From: Simon Davis
Sent: 15 February 2019 11:56
To: 'Chris Tomkins' [REDACTED]
Cc: Martin Stock <[REDACTED]>
Subject: RE: Beech Cottage, 99A North Bersted Street BE/88/18/DOC CONDITION 6

Thank you for your email. We did receive your initial site set up plan. However, WSCC Highways asked for it to be amended with an annotation to state that any reversing vehicle movements out of the site access onto North Bersted Street are undertaken with the aid of a banksman. Please see their email attached. Please amend the plan with the annotation and resubmit to me.

SITE SET UP
BE/133/16/PL
Drawing 2 - Block Plan
Scale 1:500 @ A3

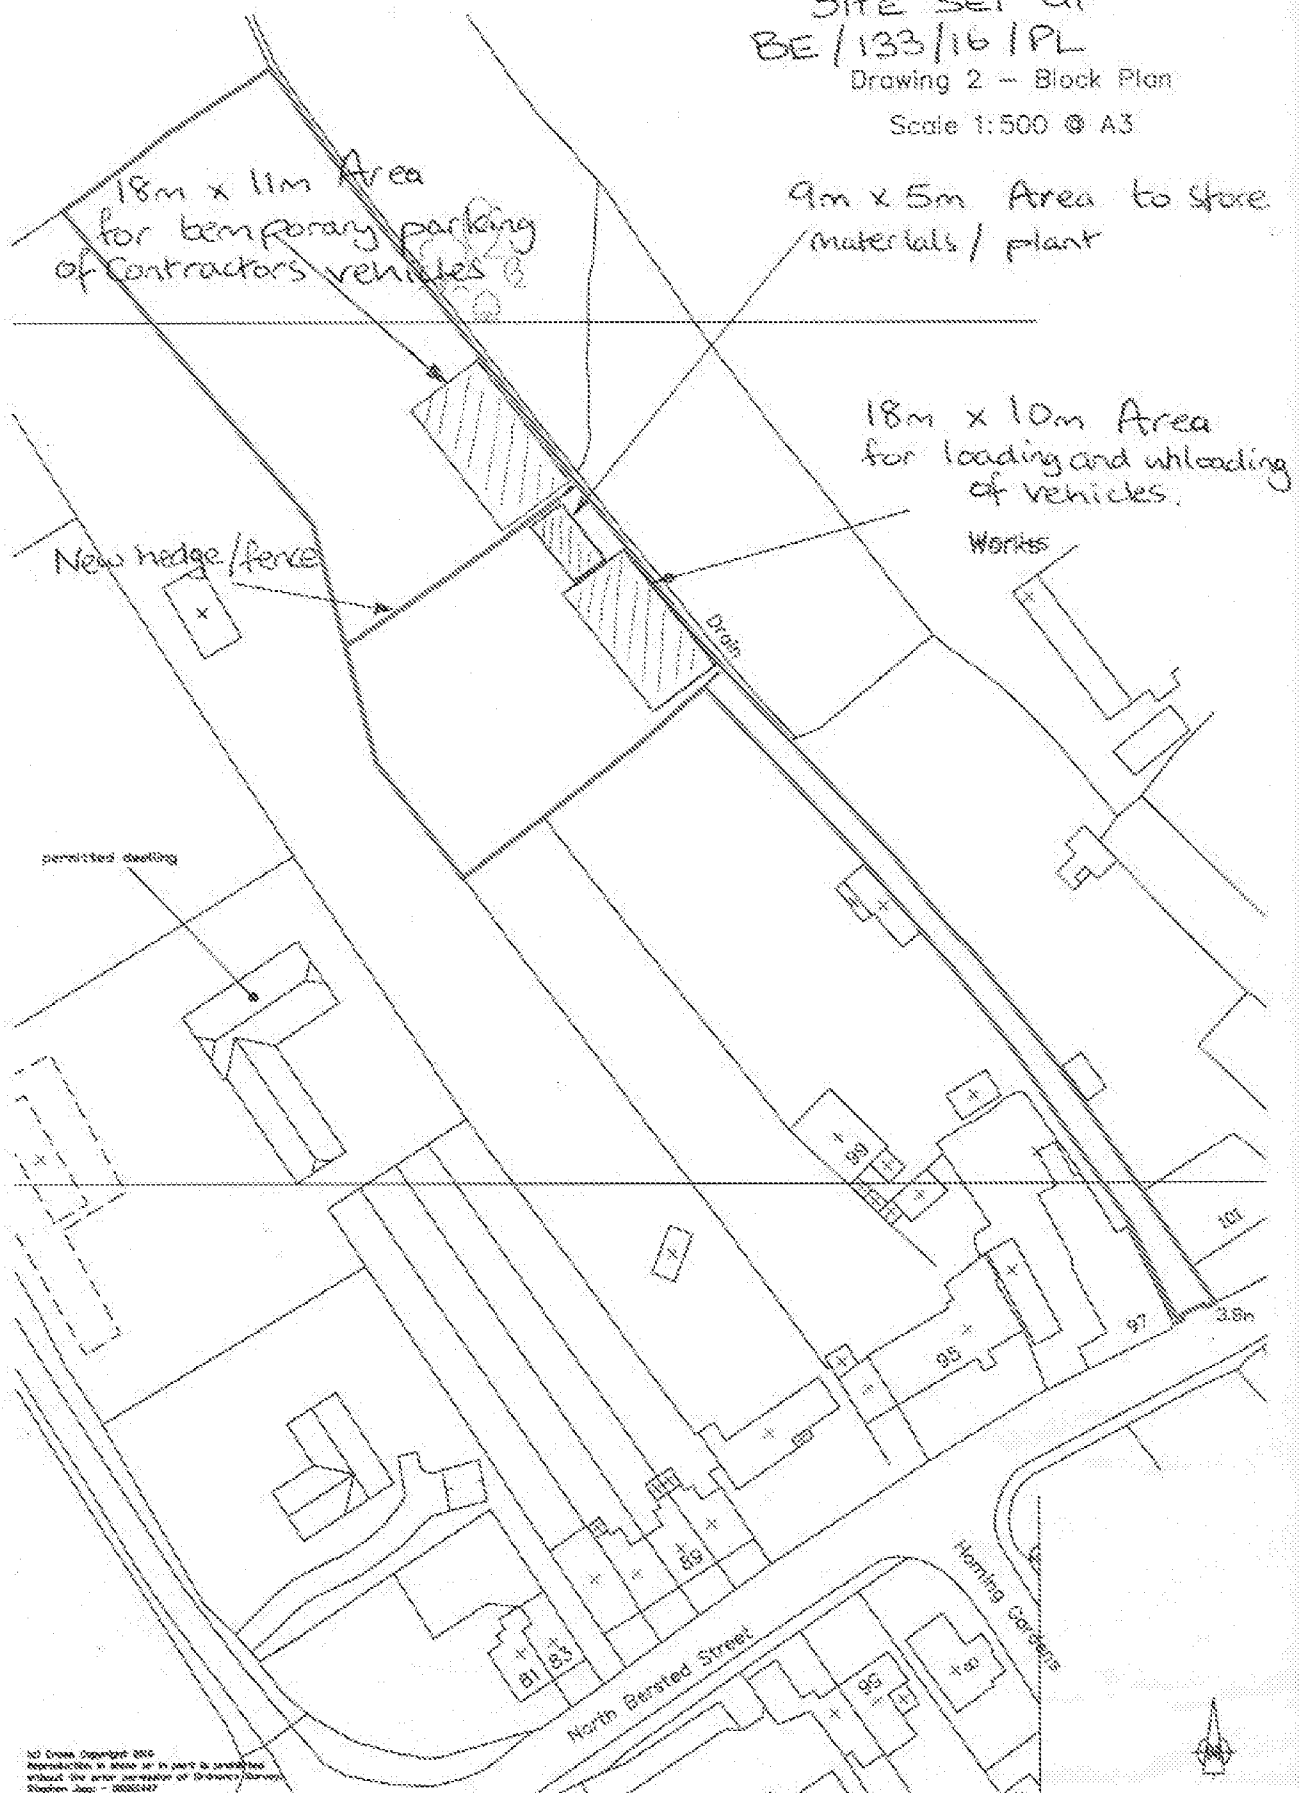
Please see attached advice from Highways re the Construction Management Plan. Can you amend the drawing and respond please.

Will do there's no need for any site traffic to reverse into NB Street ample turning and parking
But will amend and return to you
Thank you
